Our Ref: R/268/17/PL
Your Ref:

Town & Country Planning Act 1990 (as amended)
Town and Country Planning (Development Management Procedure) (England) Order 2015
Application for Planning Permission

Development Refurbishment of existing single storey building for community use, including elevational changes.
Location WRVS Centre Broadmark Parade Broadmark Lane Rustington

PROPOSED GA PLAN & ELEVATIONS

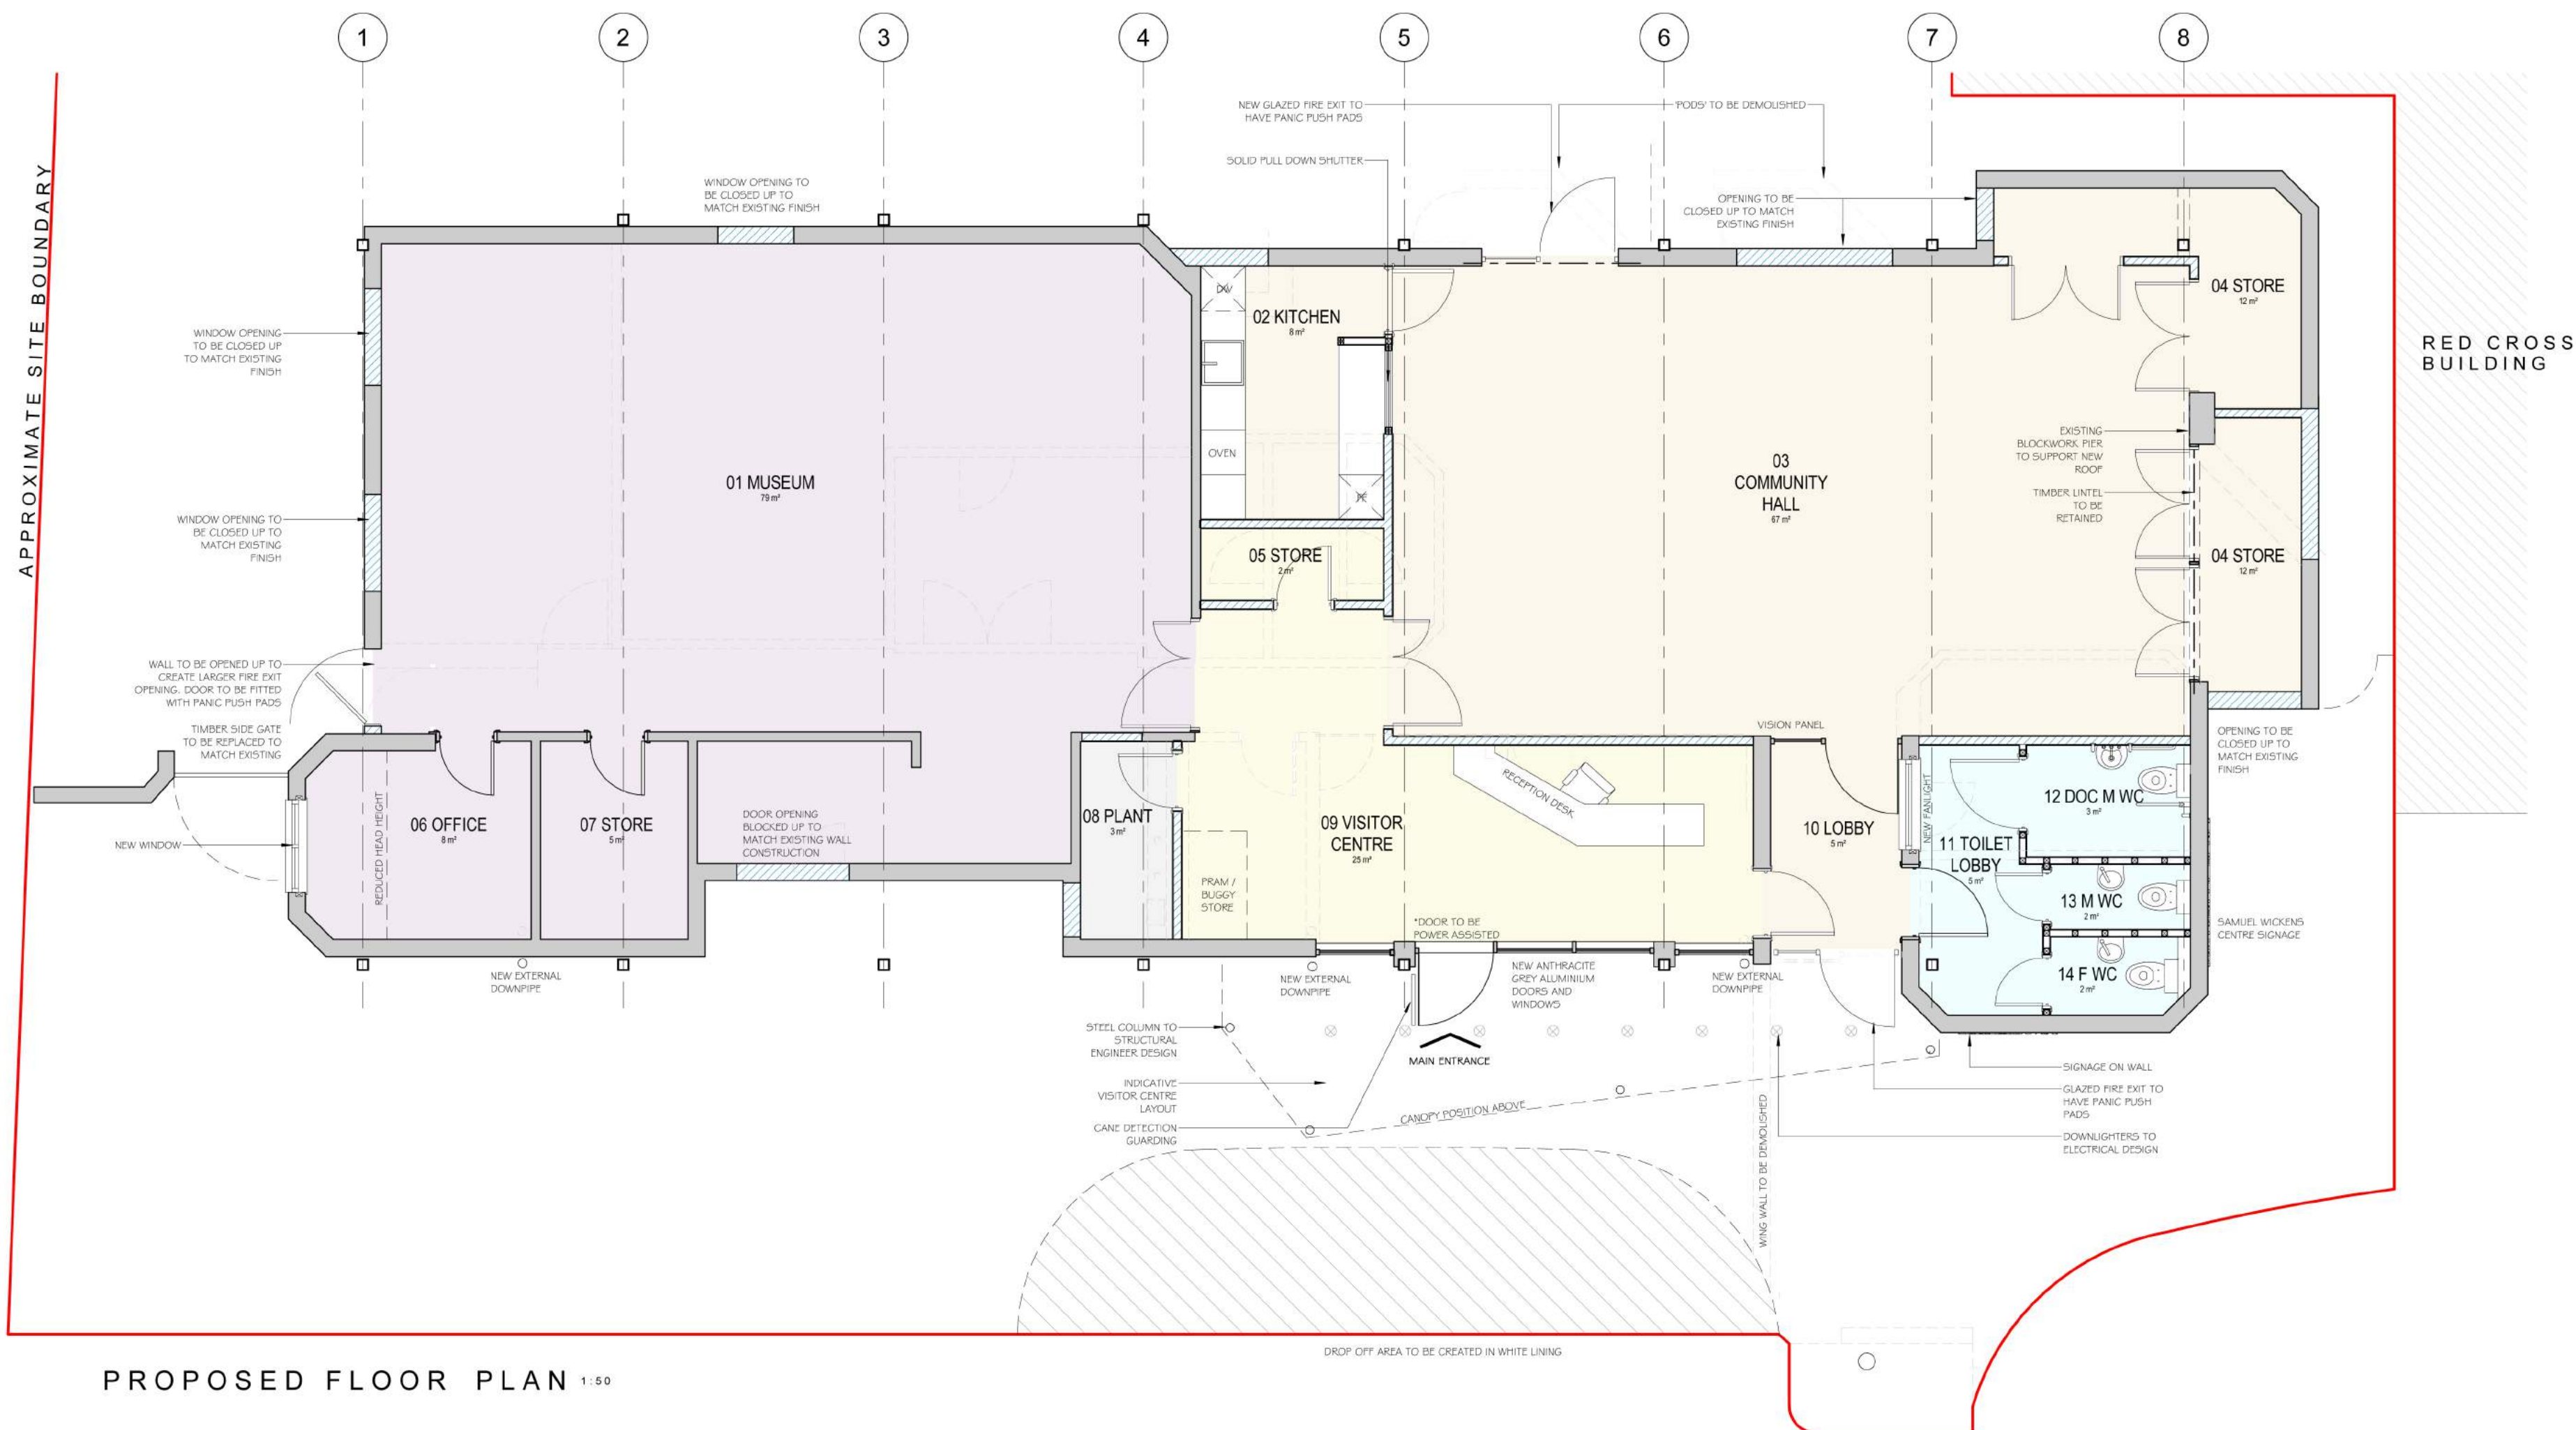
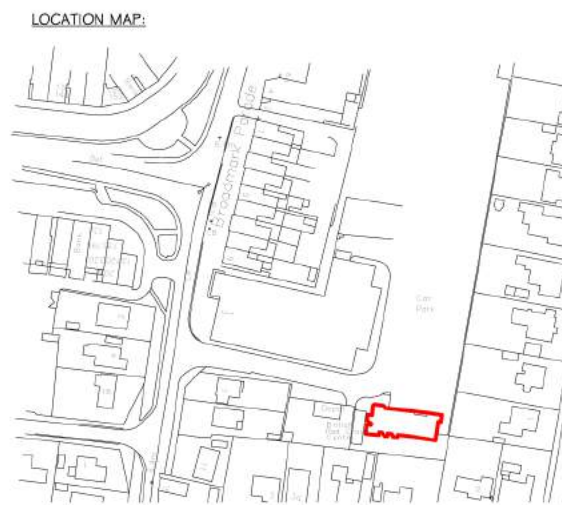
The existing and proposed east and west elevations have been labelled incorrectly. Please amend accordingly.

EXISTING FLOOR PLAN & ELEVATIONS

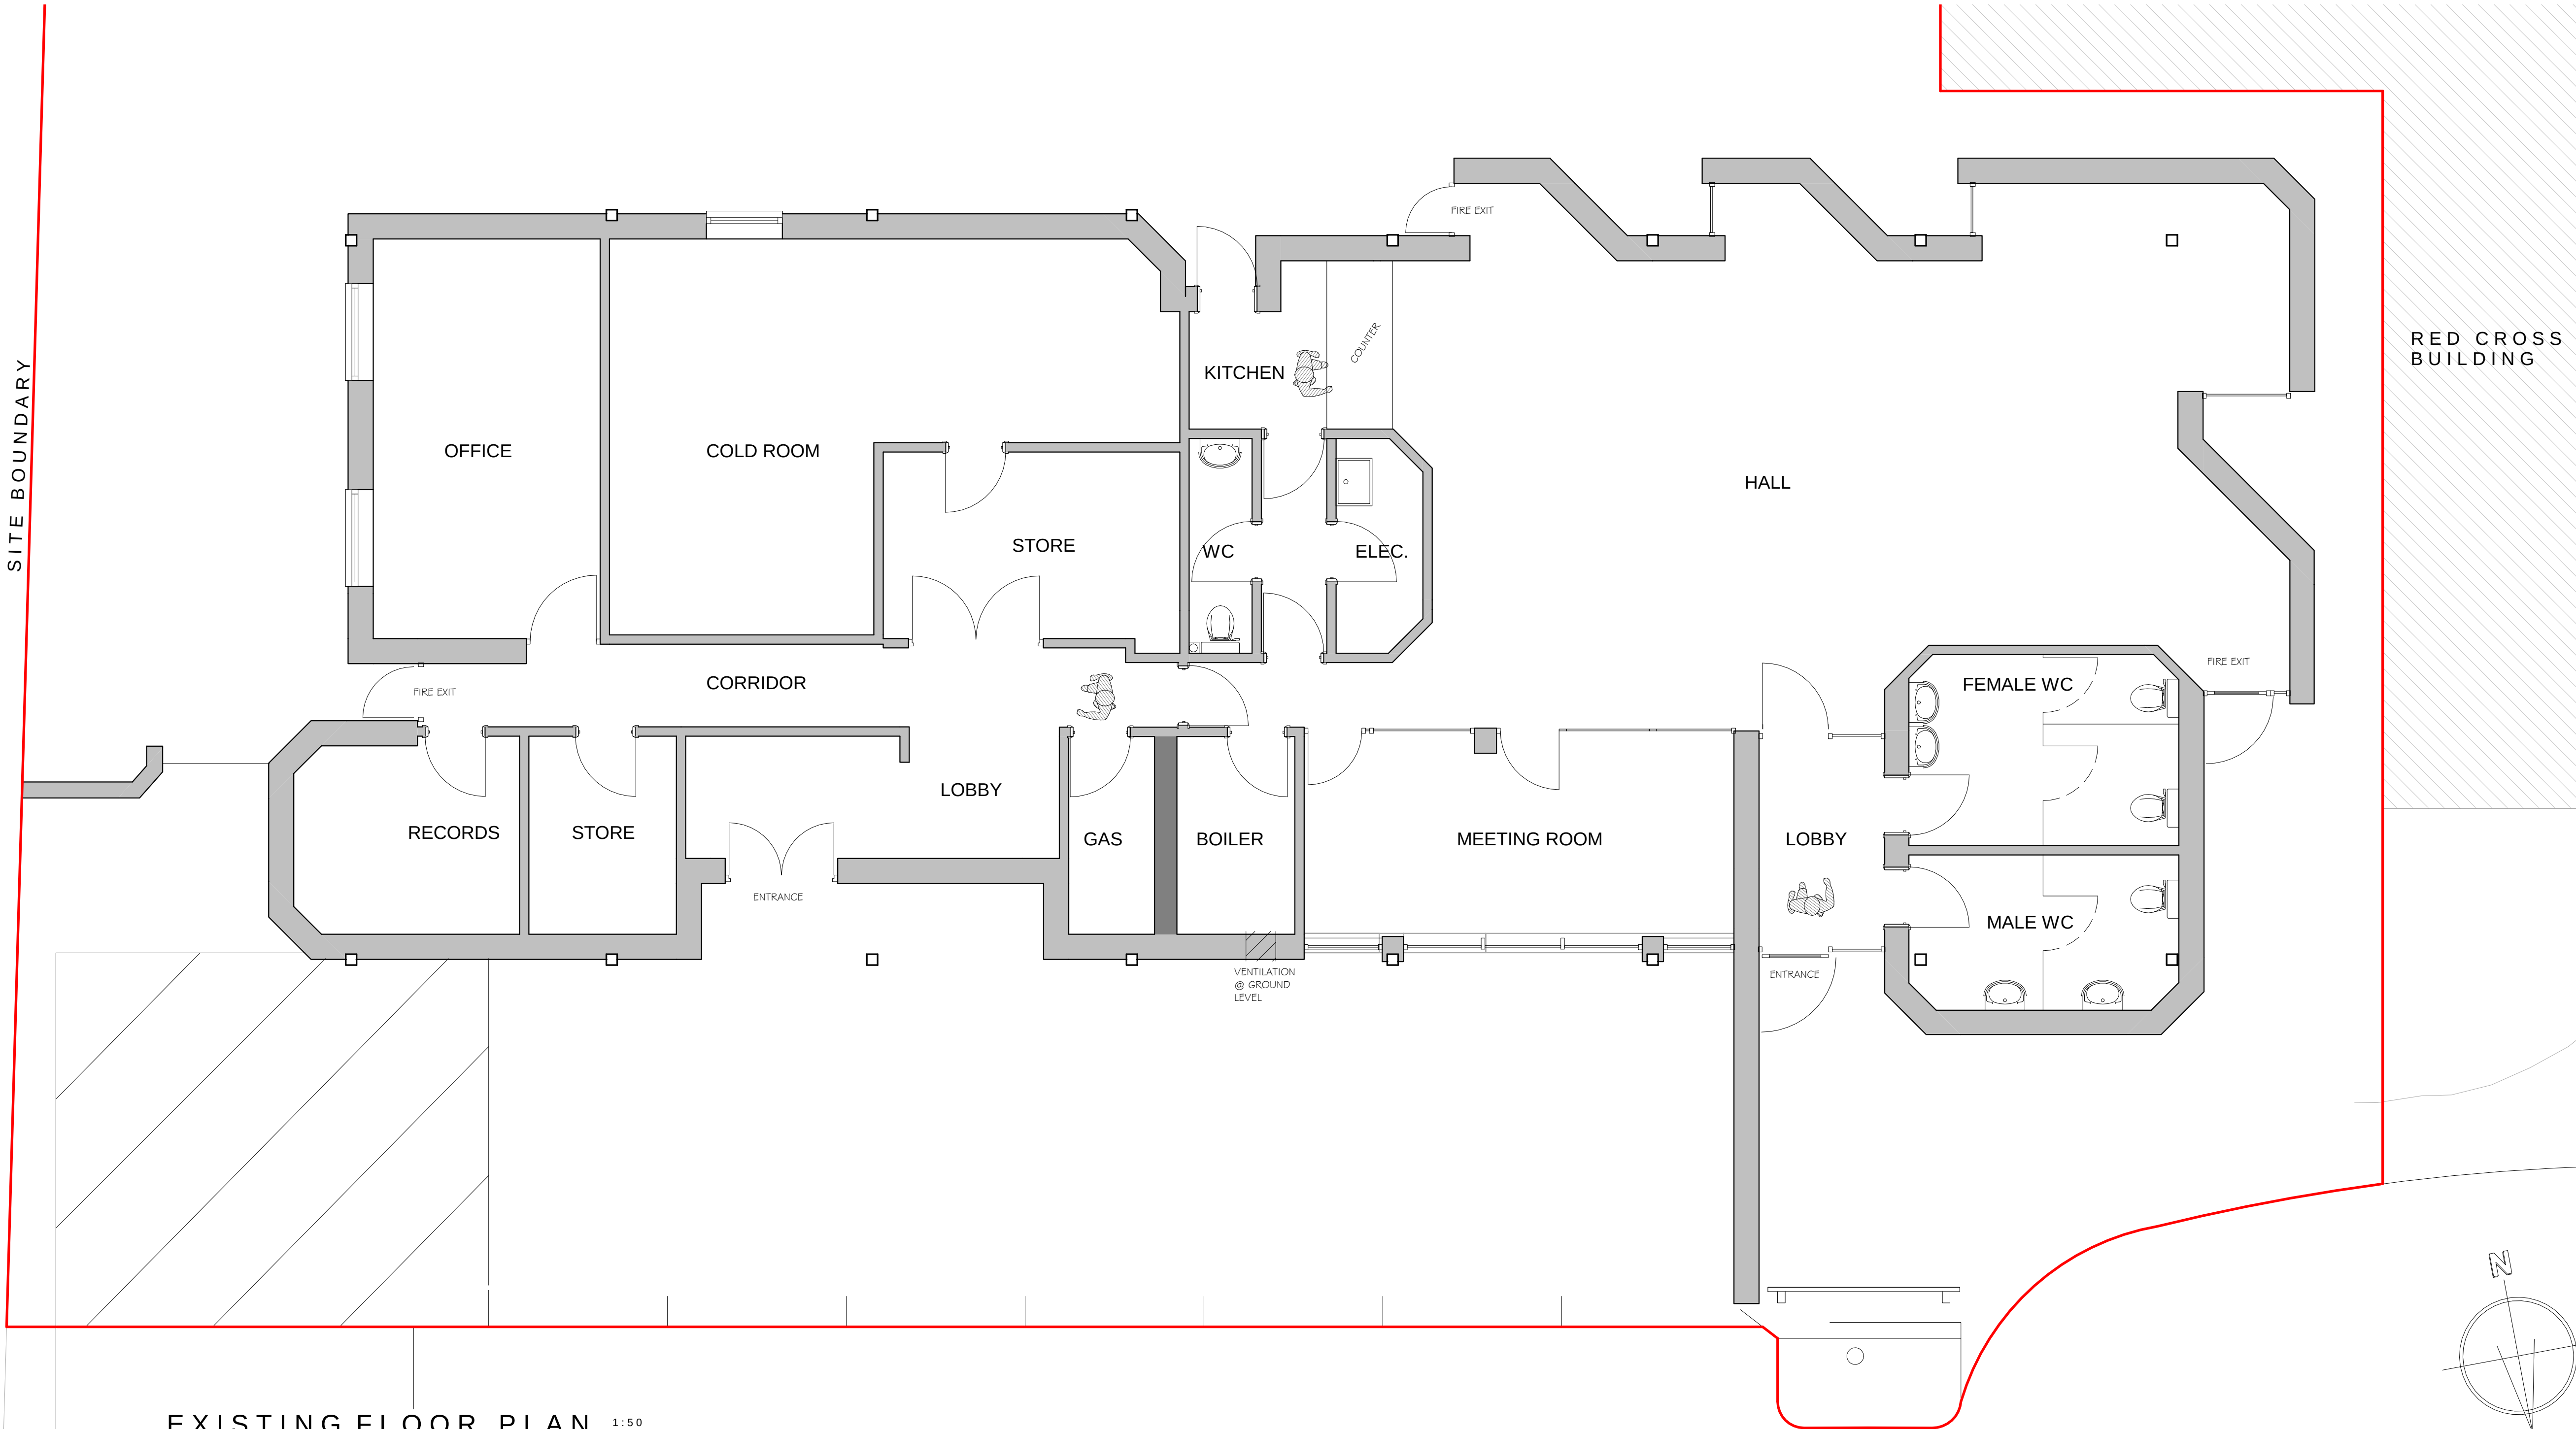
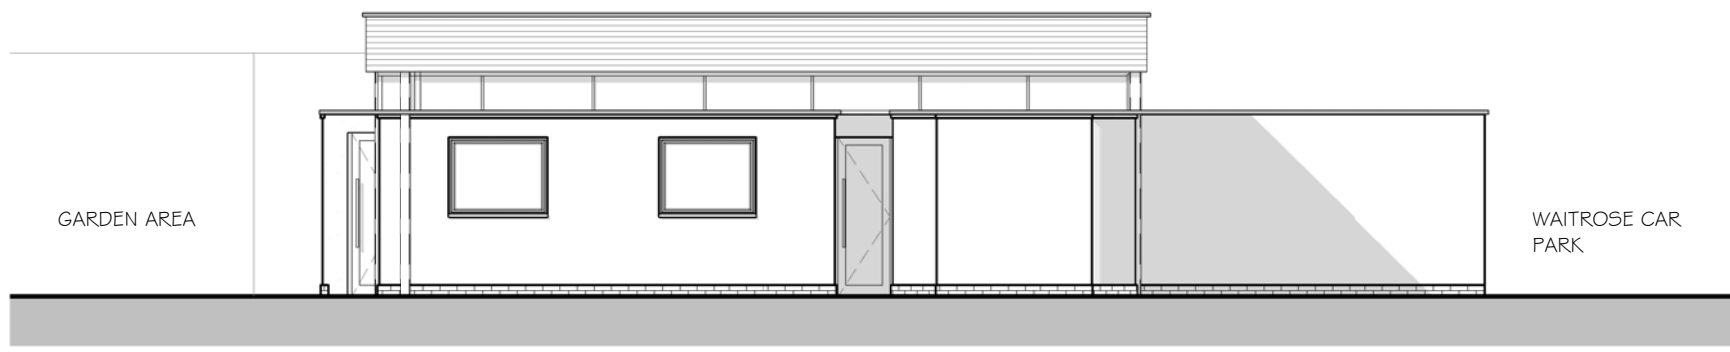
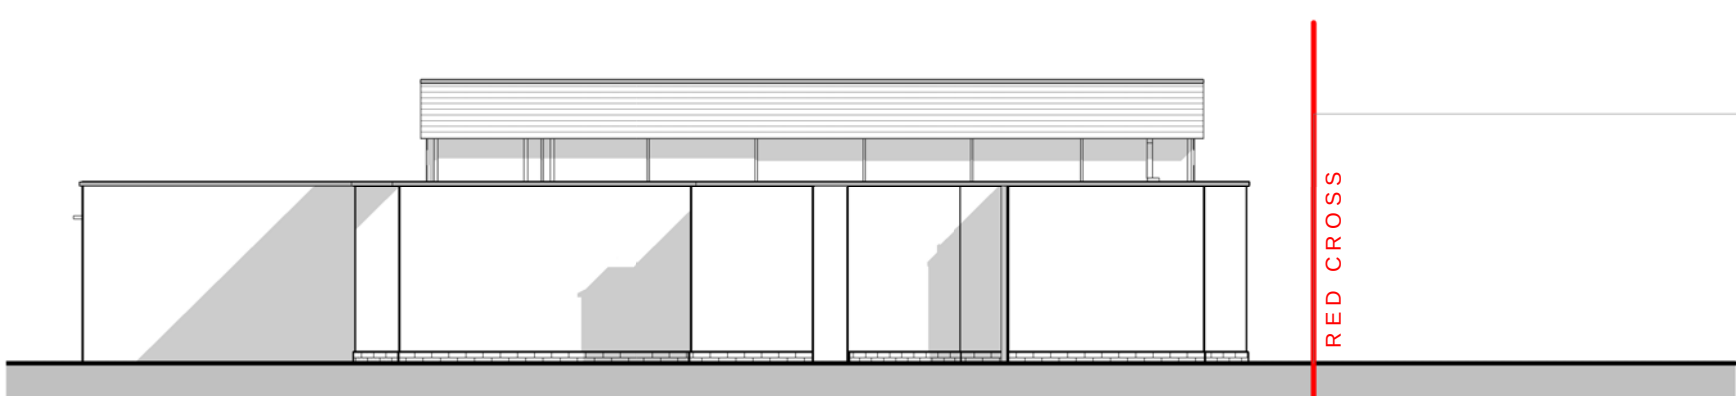
The existing floor plan and elevations do not scale correctly. Please amend accordingly.
